GRADING AND EROSION CONTROL PLAN CHECKLIST

Site: A-1 Chipseal **Location: 7245 Cole View** **COM-22-014**

A-1 CHIPSEAL
GRADING AND EROSION CONTROL PLAN
EROSION CONTROL PLAN

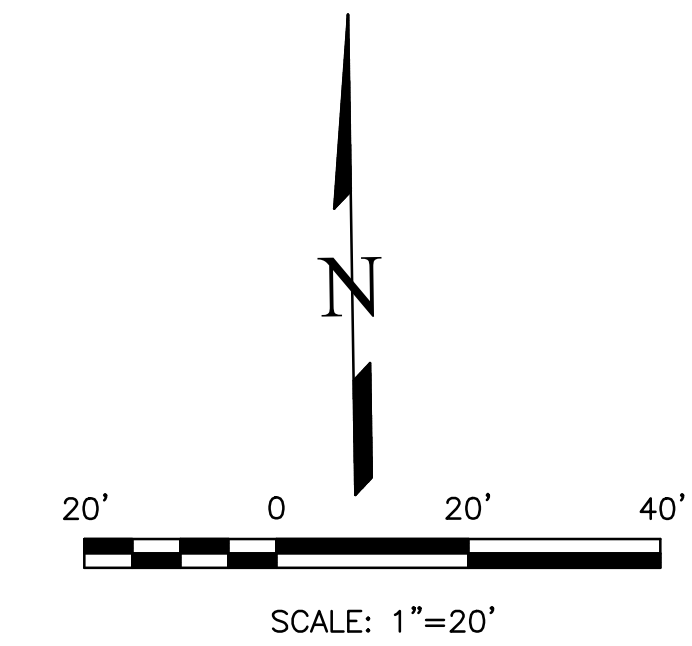
l	Existing and proposed contours 2 feet or less (except for hillside).	X	✗
m	Limits of disturbance delineating all anticipated areas of soil disturbance.	X	✗
n	Identify and protect areas outside of the construction site boundary with existing fencing, construction fencing or other methods as appropriate.	X	✓
o	Offsite grading clearly shown and called out.	N/A	N/A
p	Areas of cut and fill identified.	X	✓
q	Conclusions from soils/geotechnical report and geologic hazards report incorporated in grading design (slopes, embankments, materials, mitigation, etc.)	X	✓
r	Proposed slopes steeper than 3:1 with top and toe of slope delineated. Erosion control blanketing or other protective covering required.	N/A	N/A
s	Stormwater flow direction arrows.	N/A	✓
t	Location of any dedicated asphalt / concrete batch plants.	N/A	N/A
u	Areas used for staging, storage of building materials, soils (stockpiles) or wastes. The use of construction office trailers requires PCD permitting.	X	✓

v	All proposed temporary construction control measures, structural and non-structural. Temporary construction control measures shall be identified by phase of implementation to include "initial," "interim," and "final" or shown on separate phased maps identifying each phase.	X	✓
w	Vehicle tracking provided at all construction entrances/exits. Construction fencing, barricades, and/or signage provided at access points not to be used for construction.	X	N/A
x	Temporary sediment ponds provided for disturbed drainage areas greater than 1 acre.	X	N/A
y	Dewatering operations to include locations of diversion, pump and discharge(s) as anticipated at time of design.	N/A	N/A
z	All proposed temporary construction control measure details. Custom or other jurisdiction's details used must meet or exceed EPC standards.	X	✗
